Sustainable Traffic Solutions

June 25, 2024

RE: Responses to Comments on the Traffic Impact Study for the Haven School

Comments received from El Paso County on October 15, 2023

CONCEPTUAL IMPROVEMENT SKETCH FOR MILAM ROAD AT BURGESS ROAD

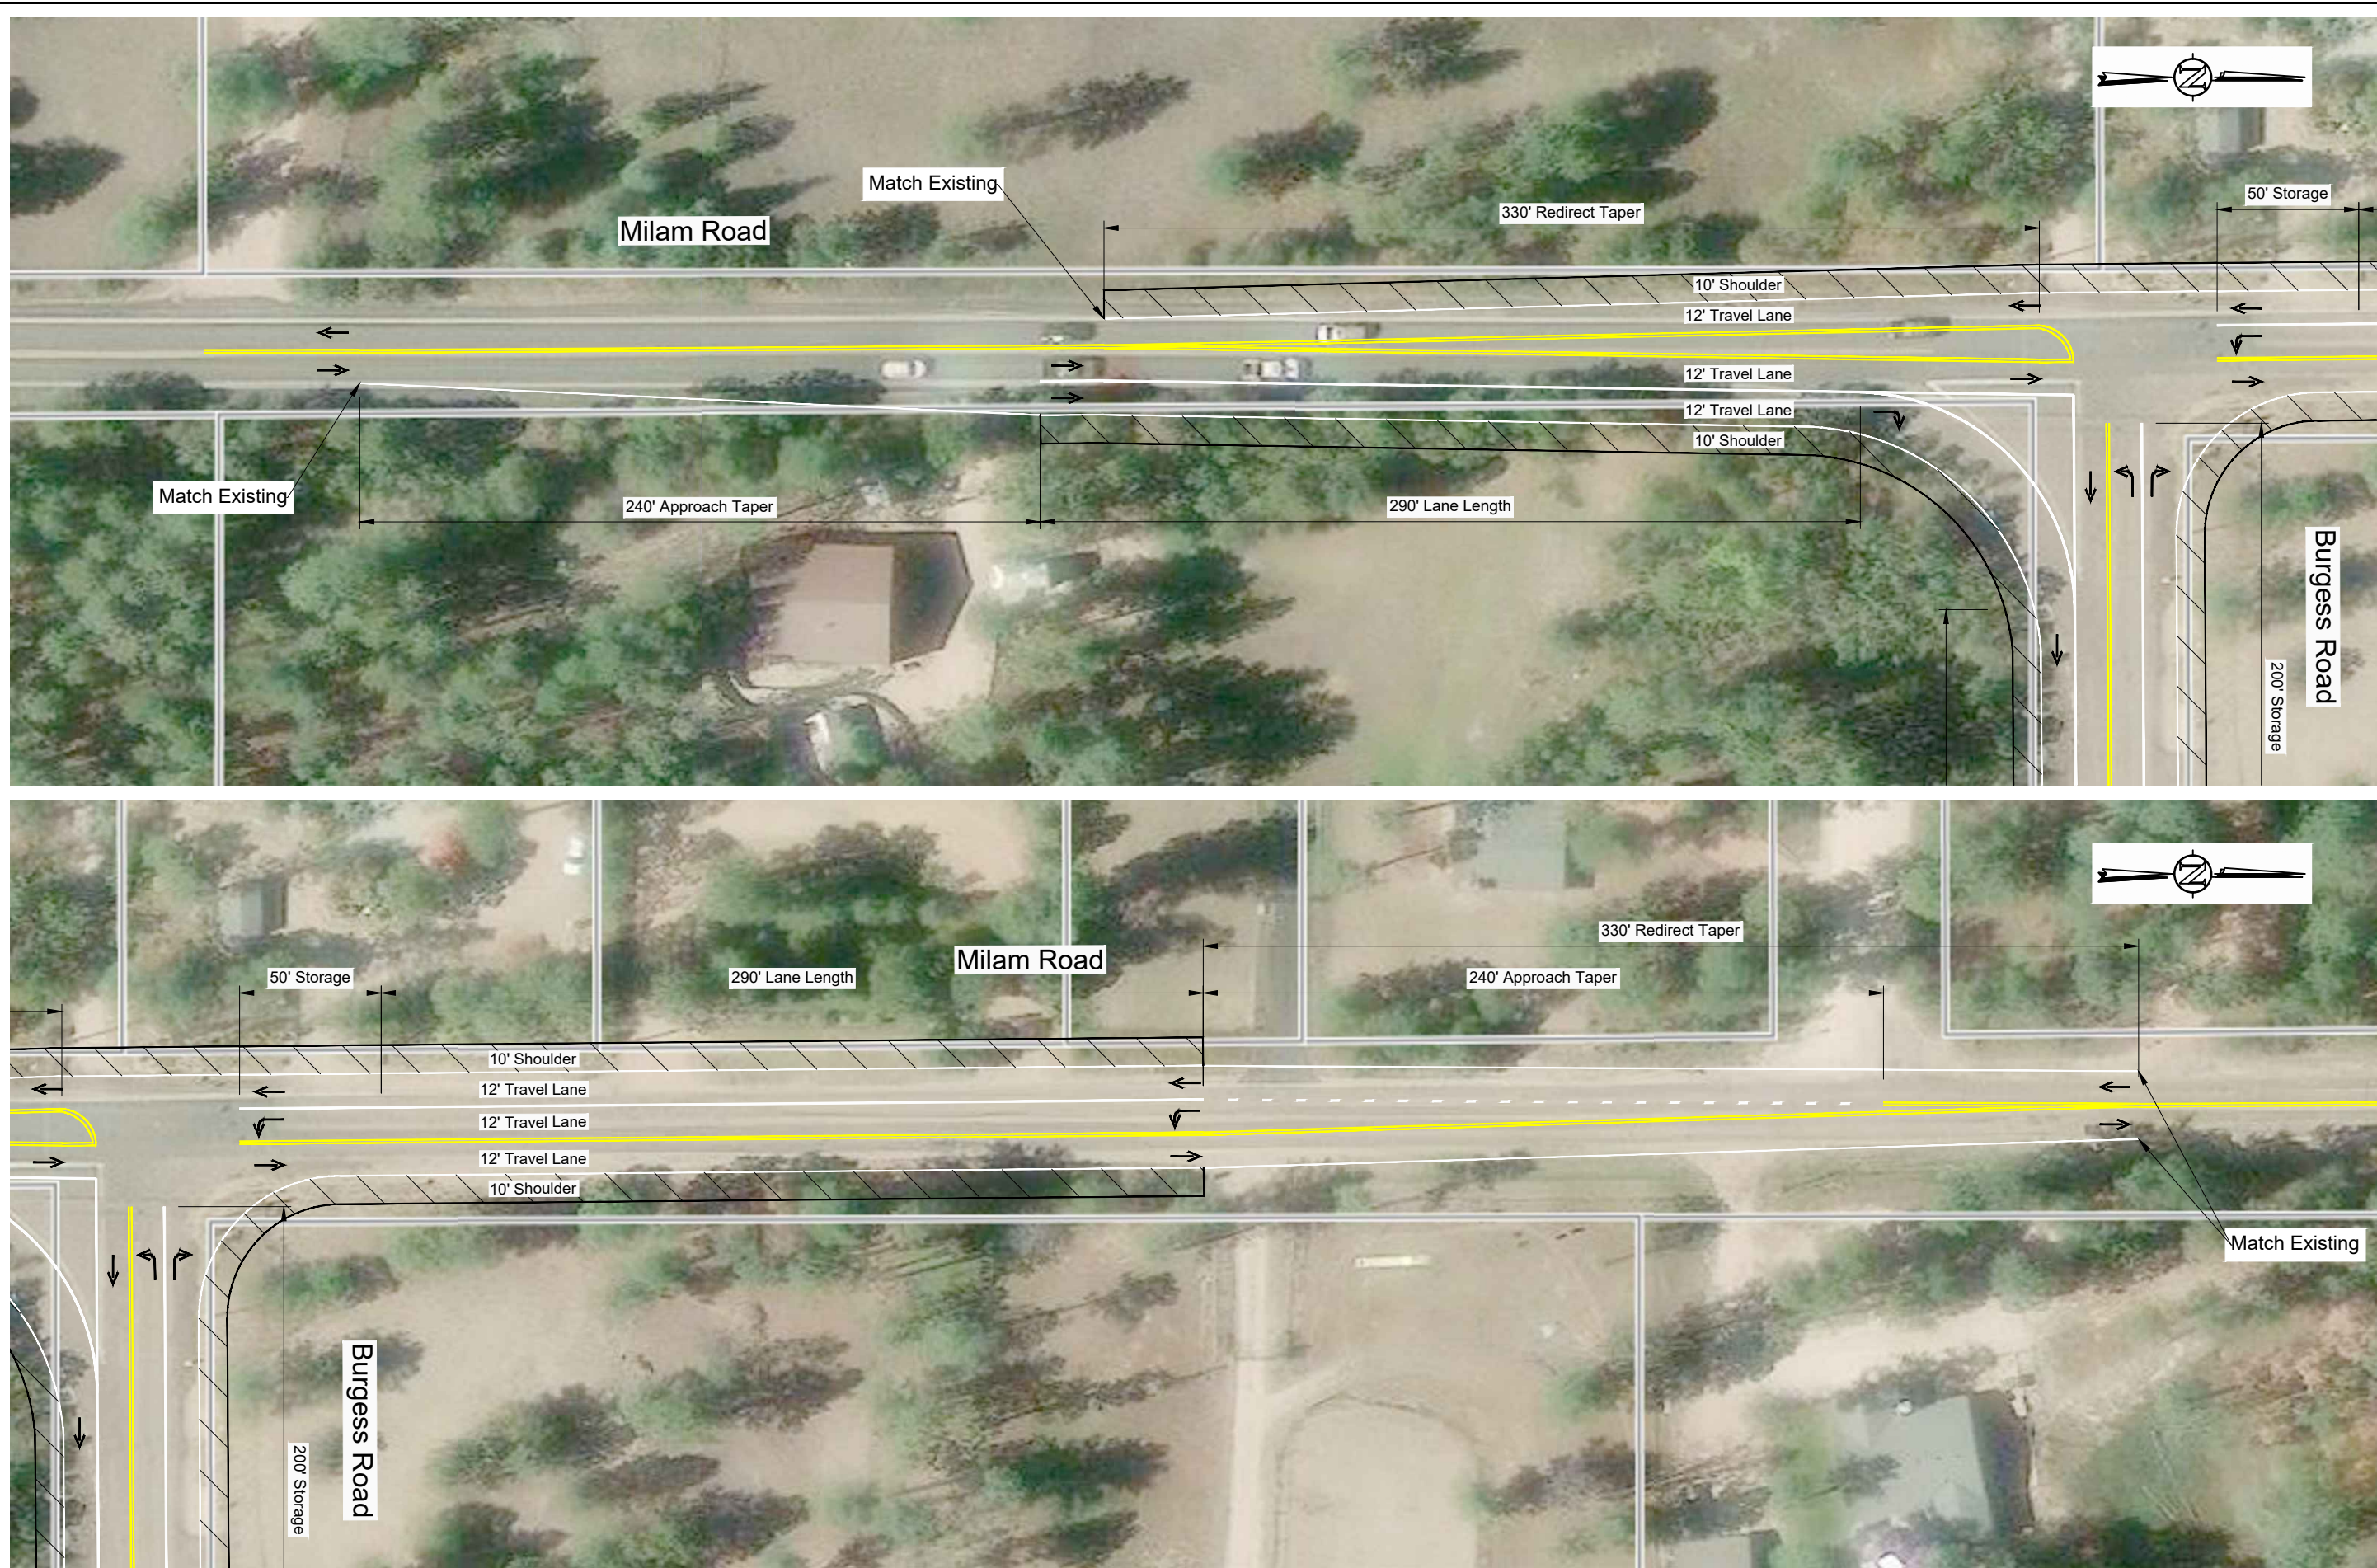
Comment 24 The addition of a southbound Milam left turn to Burgess will need to be included for an escrow cost share based on the added traffic.

Comment 25 The TIS will need to include the turn lane lengths, widths, and taper.

Comment 26 The engineer estimate for the SB turn lane will need to be included and correlate with the calculated escrow amount.

Response The estimated for the cost for the improvement is discussed in Section 9.1.

Response Refer to Tables 4 and 5.

Response The estimated for the cost for the improvement is discussed in Section 9.1.

Haven School Traffic Impact Study
CONCEPTUAL IMPROVEMENT SKETCH FOR BURGESS ROAD AT MILAM ROAD

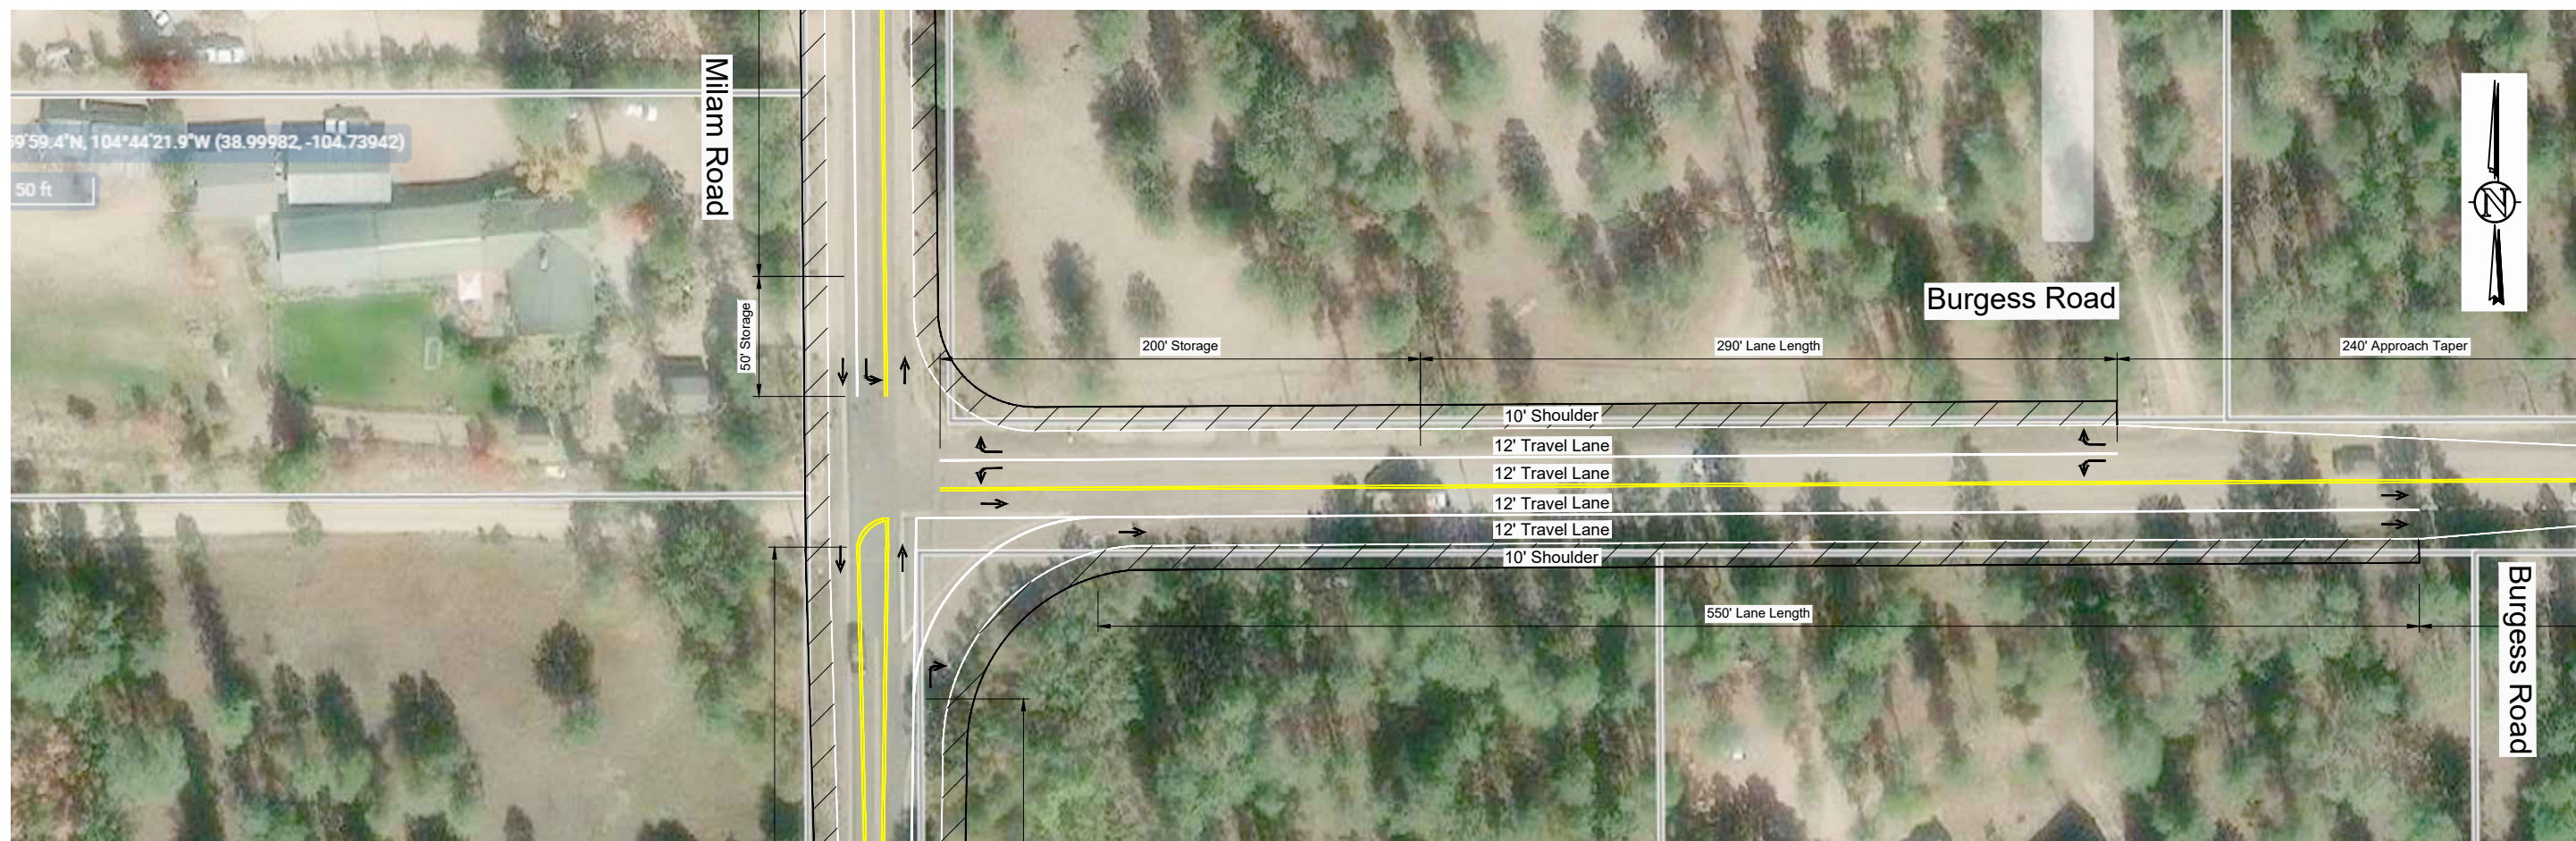
Comment 27 The westbound Burgess at Milam will need to be included for escrow cost share for right and left turn lanes based on added traffic.

Comment 28 The TIS will need to include the turn lane lengths, widths, and taper for these two turn lanes.

Comment 29 The engineer estimate for the two turns lane will need to be included and correlate with the calculated escrow amount.

Response The estimated for the cost for the improvement is discussed in Section 9.1.

Response Refer to Tables 4 and 5.

Response The estimated for the cost for the improvement is discussed in Section 9.1.

Sight Distance for Vehicles Turning Right

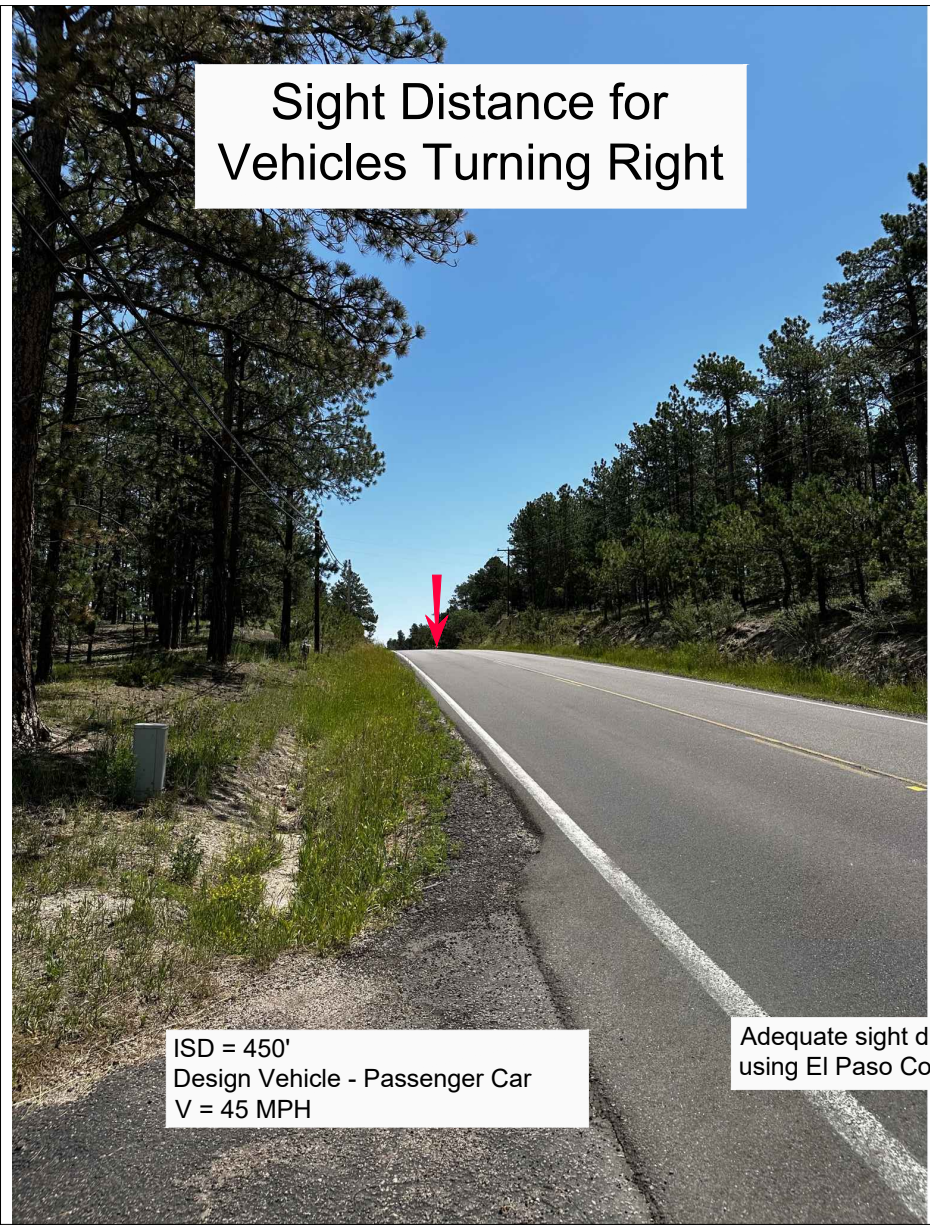
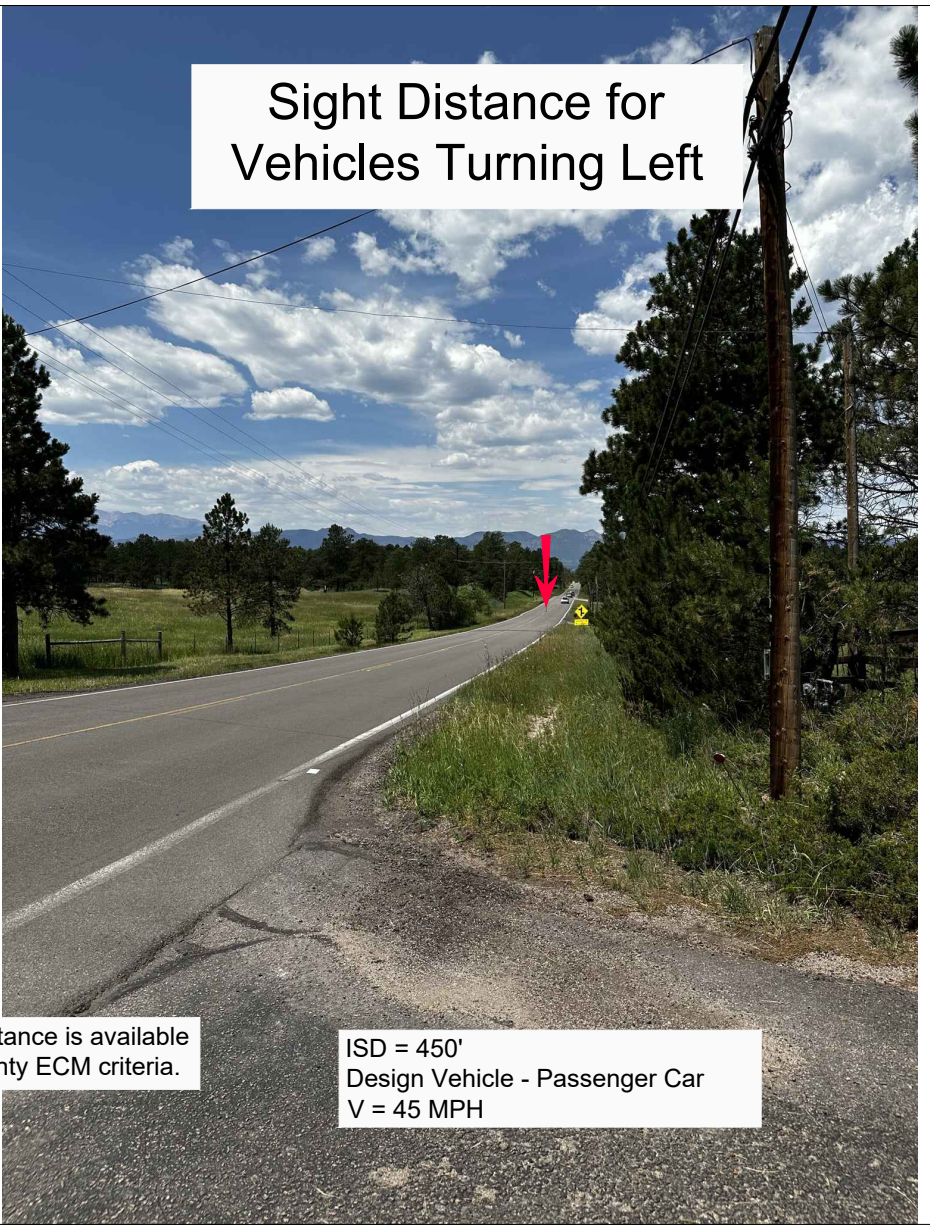
Comment 13 Please state in the text what the ECM sight distance criteria are and state whether they are met.

Comment 14 Design Vehicle Selection per ECM Table 2-36 shall be single unit truck for a school bus type route. For a school entity a school bus can be expected. Update sight distance and submit a deviation if not met.

Response The change was made.

Response The entering sight distance was only verified for the passenger vehicle because buses and trucks are not expected to use the access based on information provided by the Haven School. Considering the vertical geometry, there isn't enough sight distance to accommodate a school bus.
